St Aloysius' College SSDA 8669

Traffic and Parking Peer Review

Department of Planning and Environment

21 March 2019

Figure 7 – Existing Formal Pedestrian Crossing Facilities

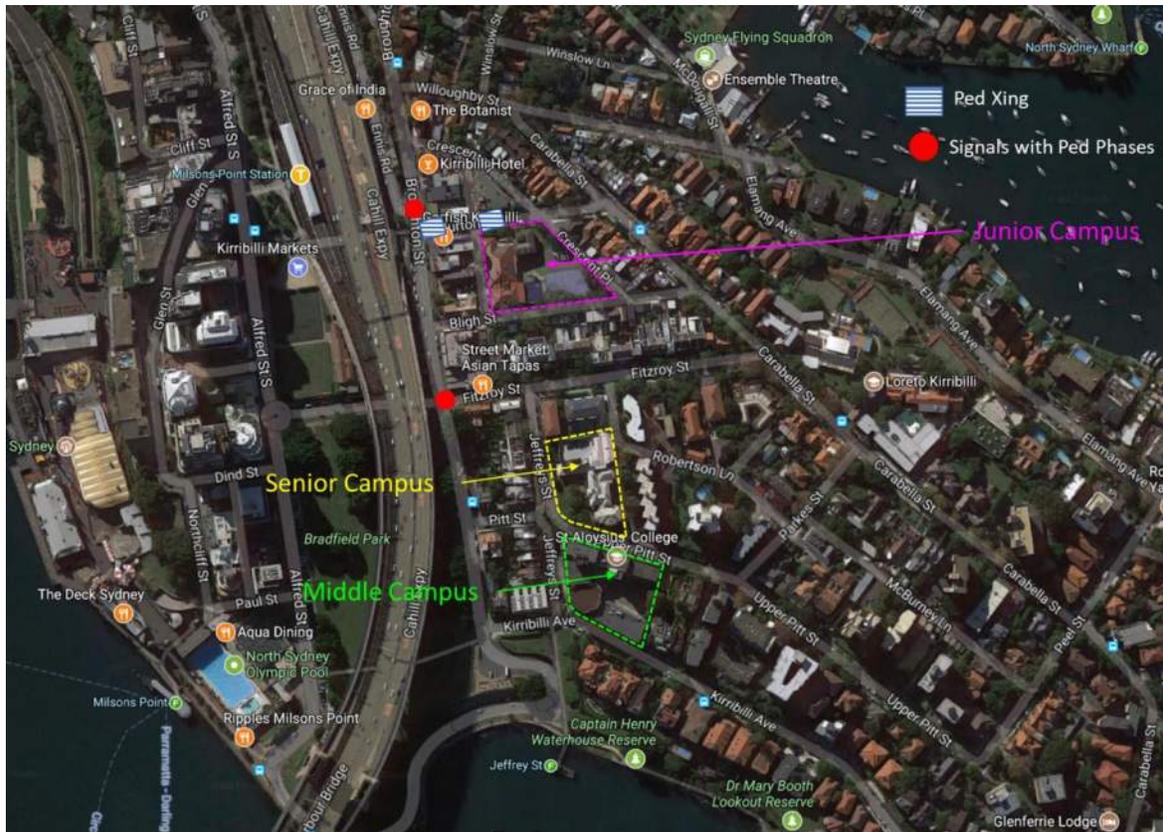
No information is provided about the use of existing pedestrian crossings and any existing shortcomings to be addressed. The type of information that would be useful to understand the existing situation includes:

- How crowded the crossings and footpaths are
- Whether crossings cause delays to traffic
- Whether existing pedestrian numbers warrant additional crossing facilities
- Crash history involving pedestrians
